Flora and Fauna Issues (Response Report)

Lot 211 DP 1044292
Pacific Highway Moonee

JULY 2010

A REPORT PREPARED FOR
GEOFF SMYTH CONSULTING PTY LTD

VEGETATION COMMUNITIES/ ASSET PROTECTION ZONES

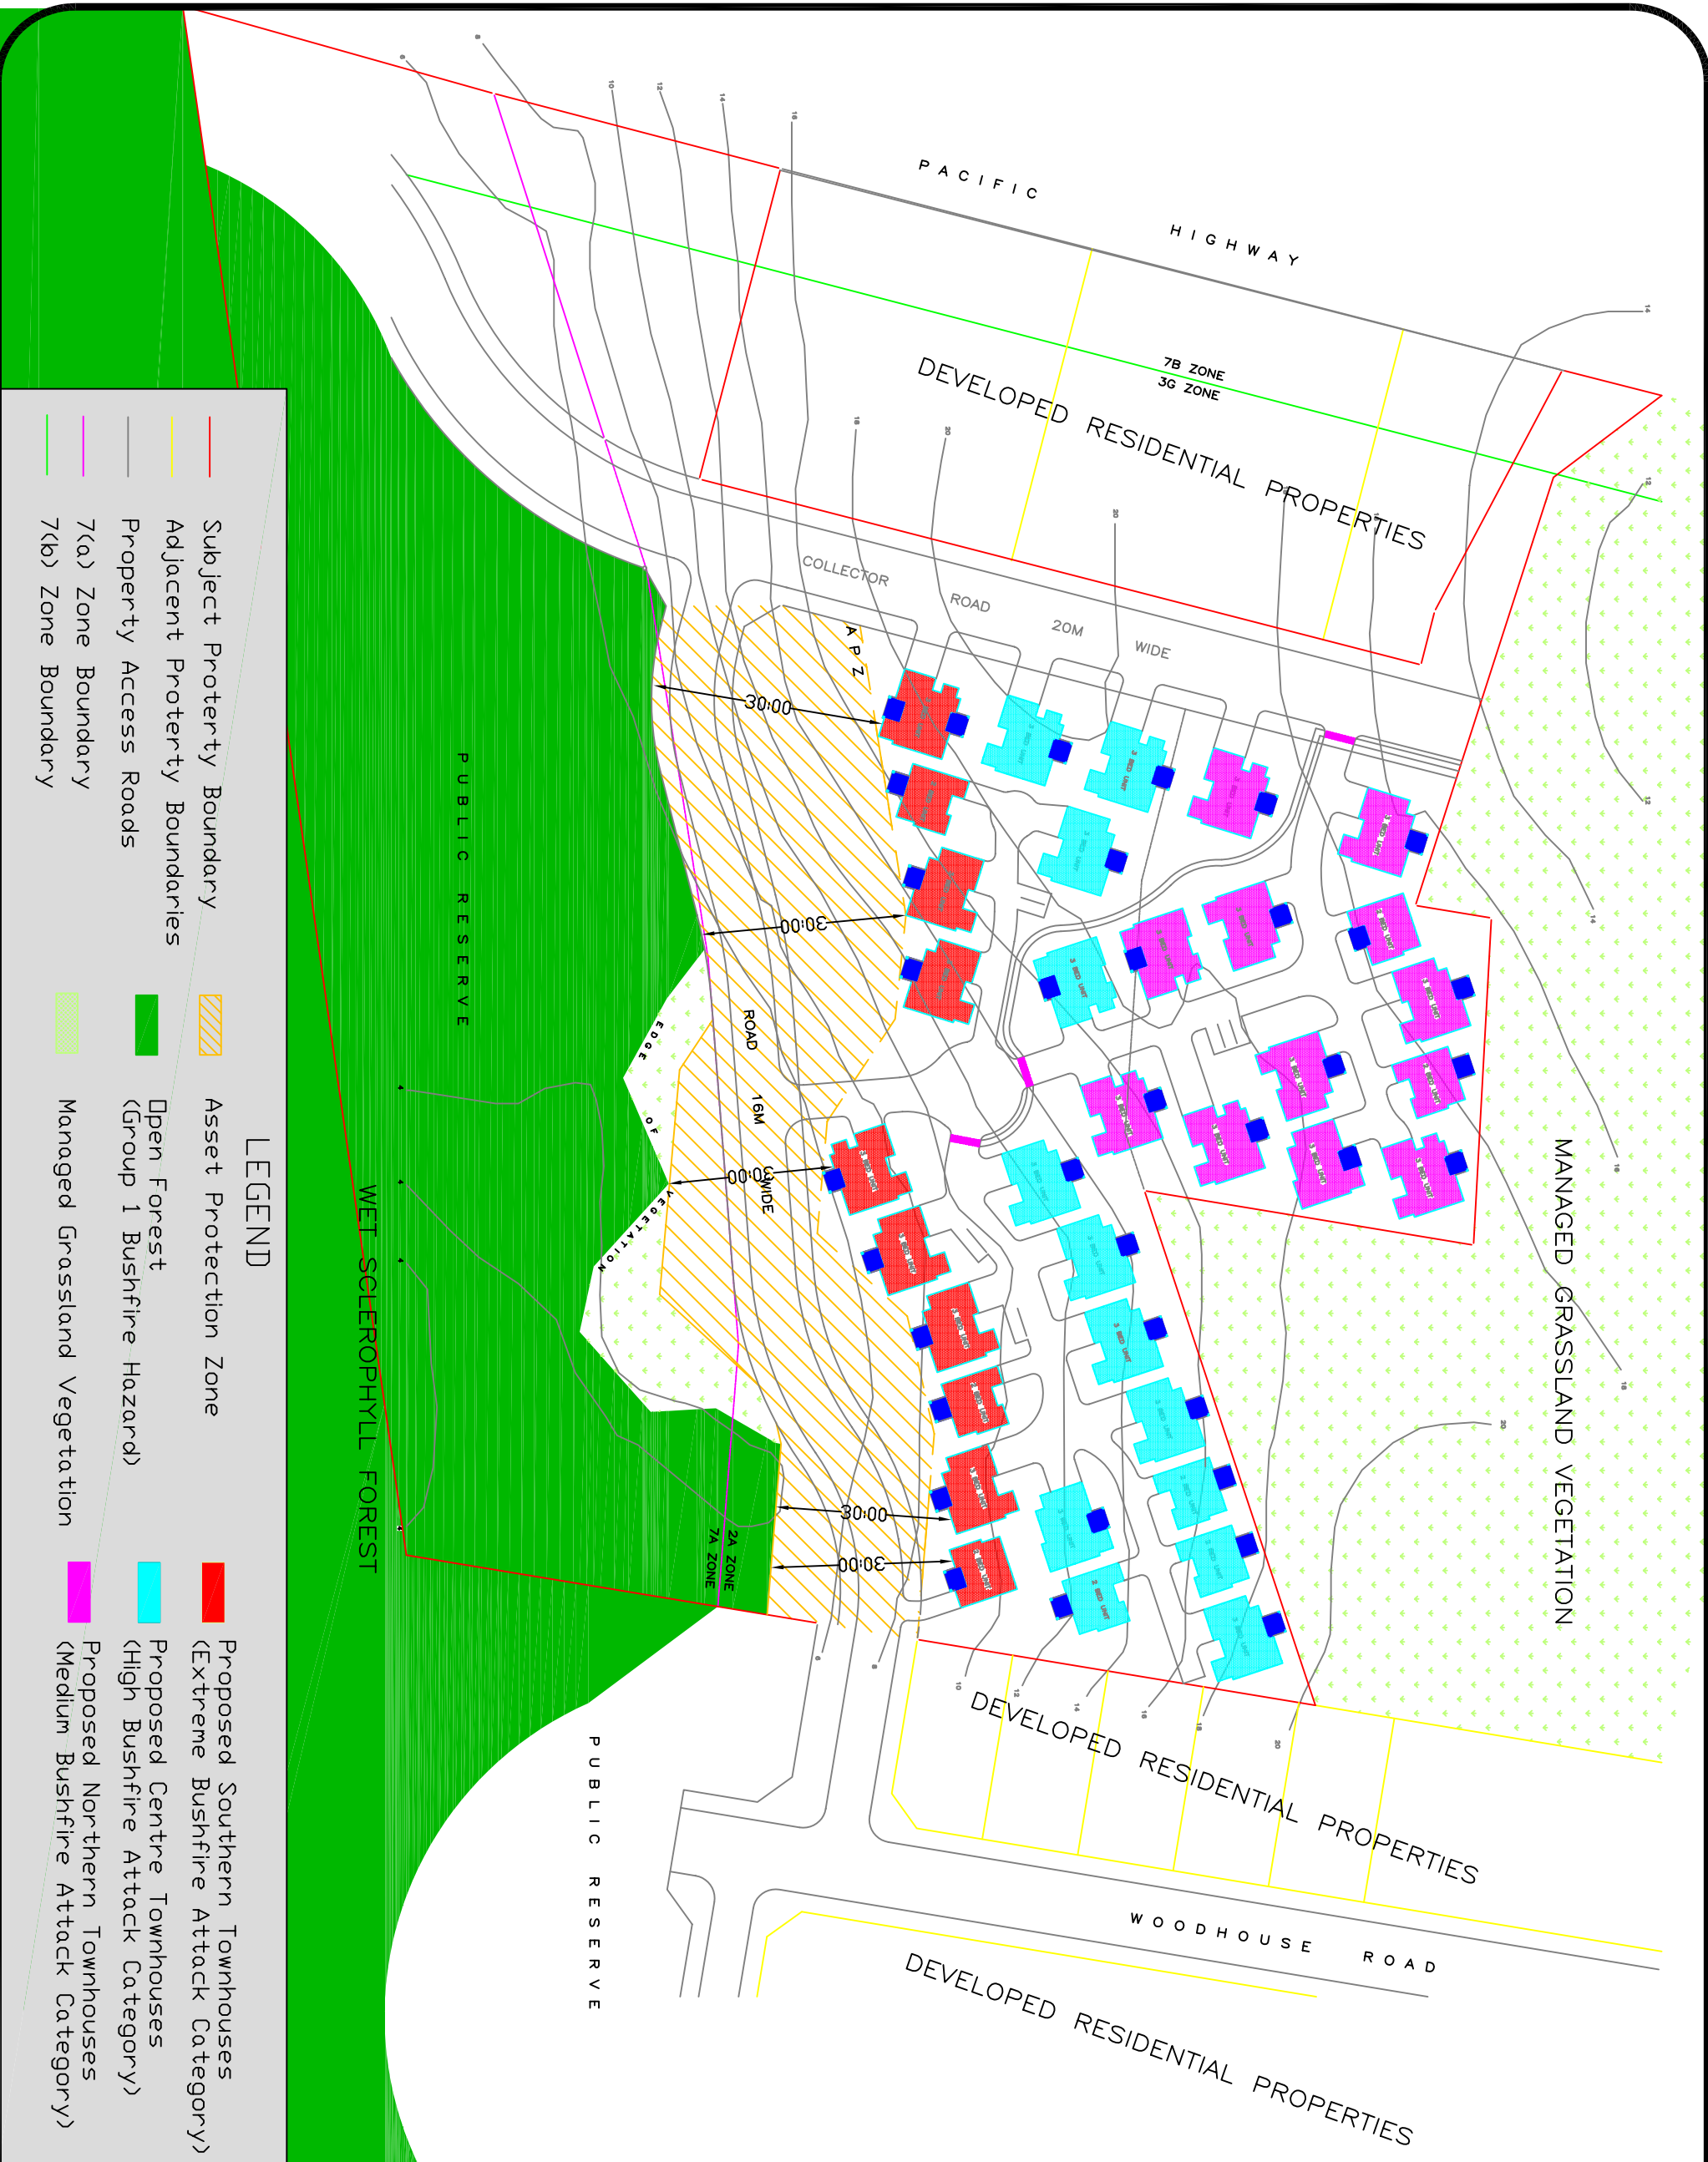
“Revise and amend the development proposal to ensure that no component, including the bushfire asset protection zones, encroach on to the lands currently zoned as 7a.”

A Bushfire Risk Management report was prepared by BushfireSafe in 2007. The report stated that an APZ of 30 metres was required for the Southern aspect of the proposed dwelling layout. The APZ does encroach into the 7a zone by approximately 750 m², but 90% of this is already cleared land. There will be about 1200m² of land, within the 7a and outside the APZ, which will be revegetated, effectively representing a net gain in *quality* 7a zoned land. A further 1500m², outside the 7a boundary, will also be revegetated and effectively incorporated into the 7a land. A Vegetation Management Plan (VMP) will be completed to outline the strategies to be undertaken in these areas including: weed control; facilitation of natural regeneration; enhancement planting; maintenance and monitoring. The implementation of the VMP will result in an overall improvement in the quality of vegetation and the habitat value of the area. **FIGURE 7** illustrates rehabilitation areas and the effective increase to land that will be conserved.

Although there will be a minor loss of vegetation, due to clearing for the APZ requirements, rehabilitation in both the degraded areas of the 7(a) land and land directly adjacent but outside the 7(a) boundary will effectively result in a net gain of native forested vegetation that will be designated for conservation.

STAGE 2 SITE LANDSCAPING PLAN

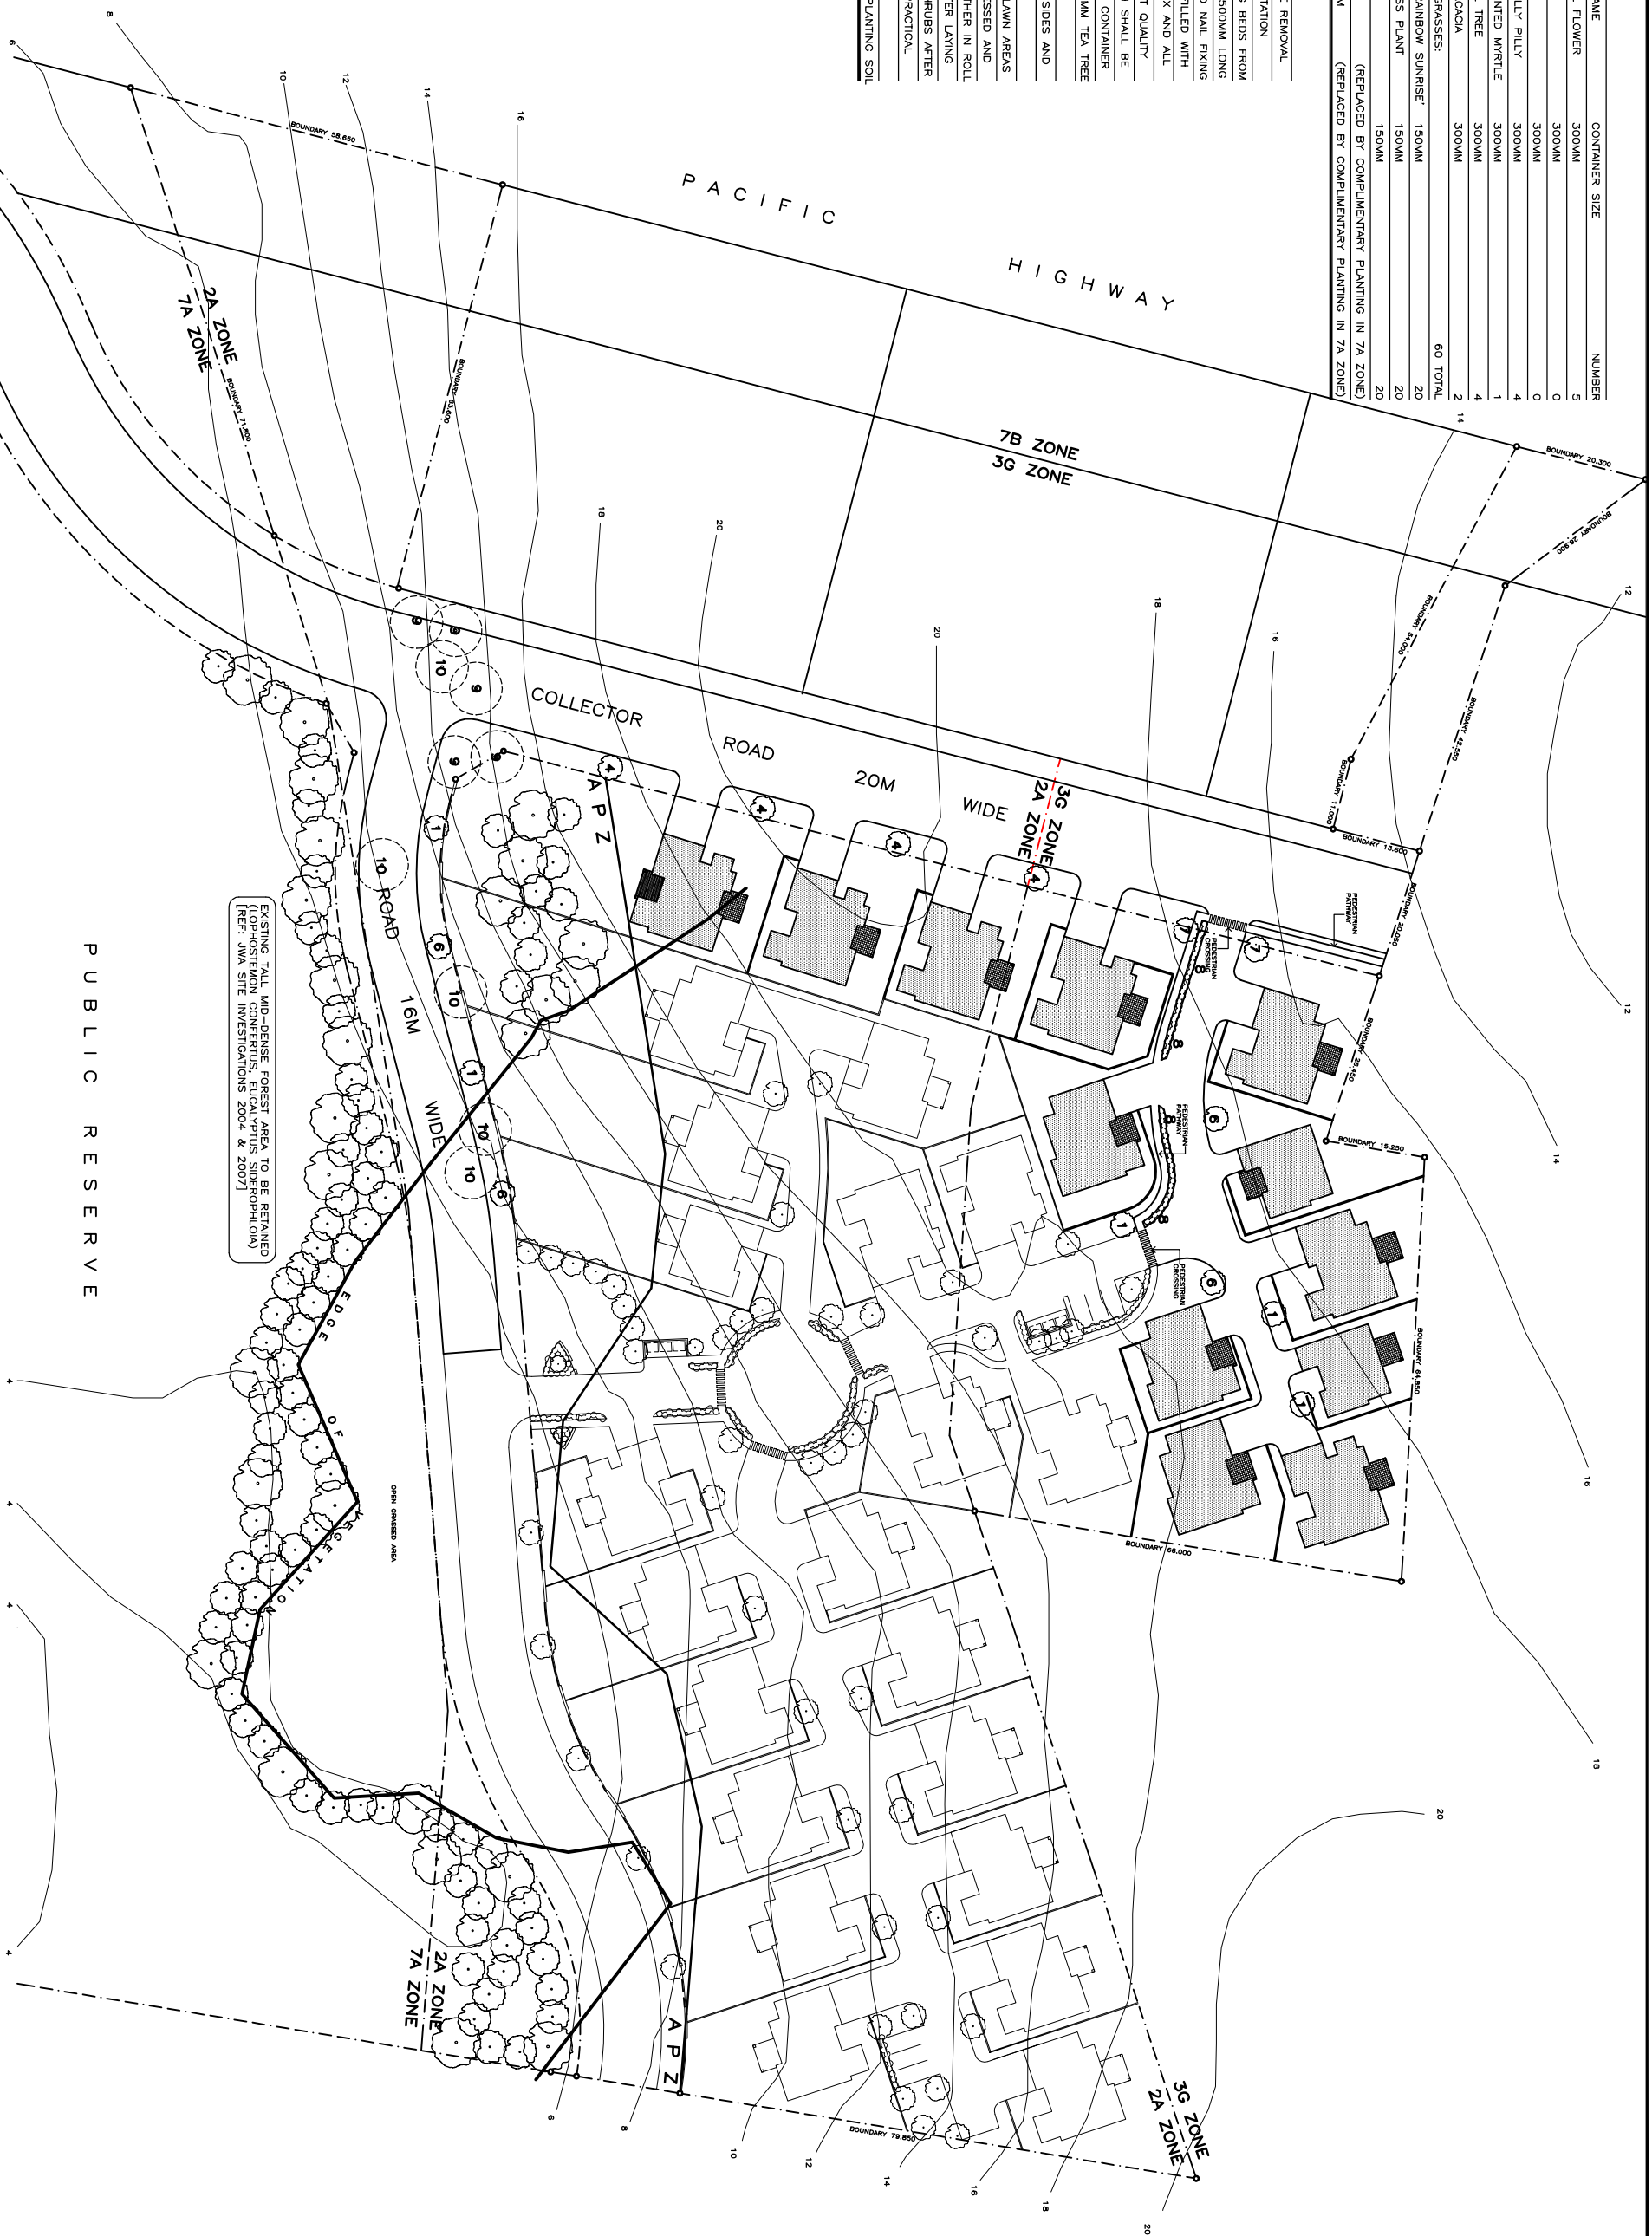
“The translocation of the Moonee Quassia or other threatened species is not supported, with in situ conservation being the preferred approach.”
